Memorandum

**RE: WESTMEAD CATHOLIC COMMUNITY
RESPONSE TO SUBMISSIONS**

As requested, please find herein The Transport Planning Partnership's (TTPP) response to submissions from agencies relating to traffic, transport and parking matters in relation to the State Significant Development (SSD-10383) as part of the Westmead Catholic Community Education Campus project.

Figure 12 Revised pick-up and drop-off layout

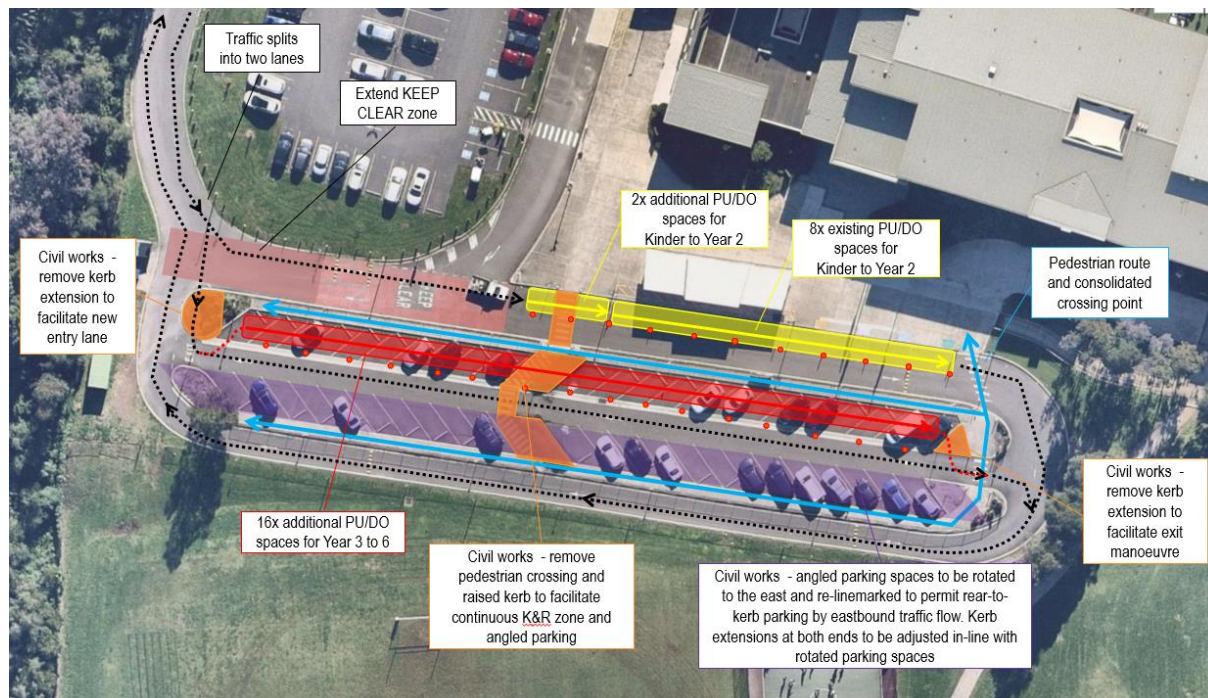
It is noted that the Project Team met with Parramatta City Council representatives on Friday 24 July 2020 to discuss the submissions in detail. Council representatives expressed queries regarding vehicle queues occurring at the existing site access off Darcy Road (west of Mons Road). Council representatives recommended that the Project Team attend a site visit with a Council representative in the morning peak period to observe the traffic conditions.

On inspection, CoPC's traffic engineer noted that queues forming on Darcy Road appeared to be the result of vehicles queueing from within the site. Upon further investigation of the operation within the site, the internal queue was formed by vehicles entering the Kiss and Ride zone. As observed on-site, the average drop-off rate was between 30-60 seconds per vehicle which is less than half the rate which was adopted in the SSDA's Transport and Accessibility Impact Assessment i.e. 2 minutes per vehicle. Therefore, it was apparent that the queuing on-site was the result of a low capacity of vehicle bays to accommodate the drop-off demand. CoPC noted that the proposed new high school Kiss and Ride facility, which will be separate to the primary school Kiss and Ride facility, will significantly improve the current and future loads on the current facility along with the implementations discussed in this RtS.

Following discussions with CoPC and upon further site investigations the configuration of the future primary school Kiss and Ride zone has been amended as shown in Figure 2. The amended layout is a refined design of the initial proposal providing traffic manoeuvring efficiencies and improved safety since it eliminates the need for vehicles to reverse into PU/DO bays. Under the amended arrangement, all PU/DO vehicular movements will occur in a forward direction which will ensure that the pick-up/drop-off activities occur as efficiently as possible and the drop-off rate could be maintained at 30-60 seconds per vehicle.

The amended layout incorporates 16 PU/DO bays in addition to the existing eight PU/DO bays. The additional PU/DO bays will be provided as parallel spaces within the former angled parking area. In order to facilitate student set-down safely on the passenger side of the vehicle, the direction of traffic flow will be switched from westbound flow to eastbound flow.

Minor adjustments to the raised kerb at both ends of the parking aisle will be proposed in order to facilitate vehicle ingress and egress movements from the new PU/DO bays. Also, the central pedestrian crossing will be removed which shall consolidate all pedestrian movements in this area to one crossing location. As a result, the amount of pedestrian-vehicle conflict points will be minimised and therefore can be more efficiently and safely managed while the Kiss and Ride facility is in operation.

By removal of the central pedestrian crossing, there will be a gain of two additional PU/DO bays at the end of the existing Kiss and Ride facility. Hence, there will be 10 PU/DO bays in the future where the Kiss and Ride facility is currently located. Overall, the amended layout for the future primary school Kiss and Ride facility provides 18 PU/DO bays in addition to the existing eight bays. Therefore, the amended proposal will comprise a total of 26 PU/DO bays.

Based on a rate of 1 minute per vehicle (as observed on-site with the City of Parramatta Council and as will be maintained by forward traffic movements) each PU/DO bay can accommodate 15 vehicles in 15 minutes. Therefore, the 26 PU/DO bays could turnover a total of 390 cars in 15 minutes (26 bays multiplied by 15 vehicles). This indicates that the capacity of the Kiss and Ride facility (390 cars) is considerably greater than the future demand (91 cars) and can sufficiently accommodate the future peak hourly traffic arriving to the facility. In fact, only seven PU/DO bays would be required to accommodate the 91 cars arriving in the peak 15-minute period. Thus, provision of 26 PU/DO bays would allow the site to accommodate four times the site-generated demand (390 cars versus 91 cars).
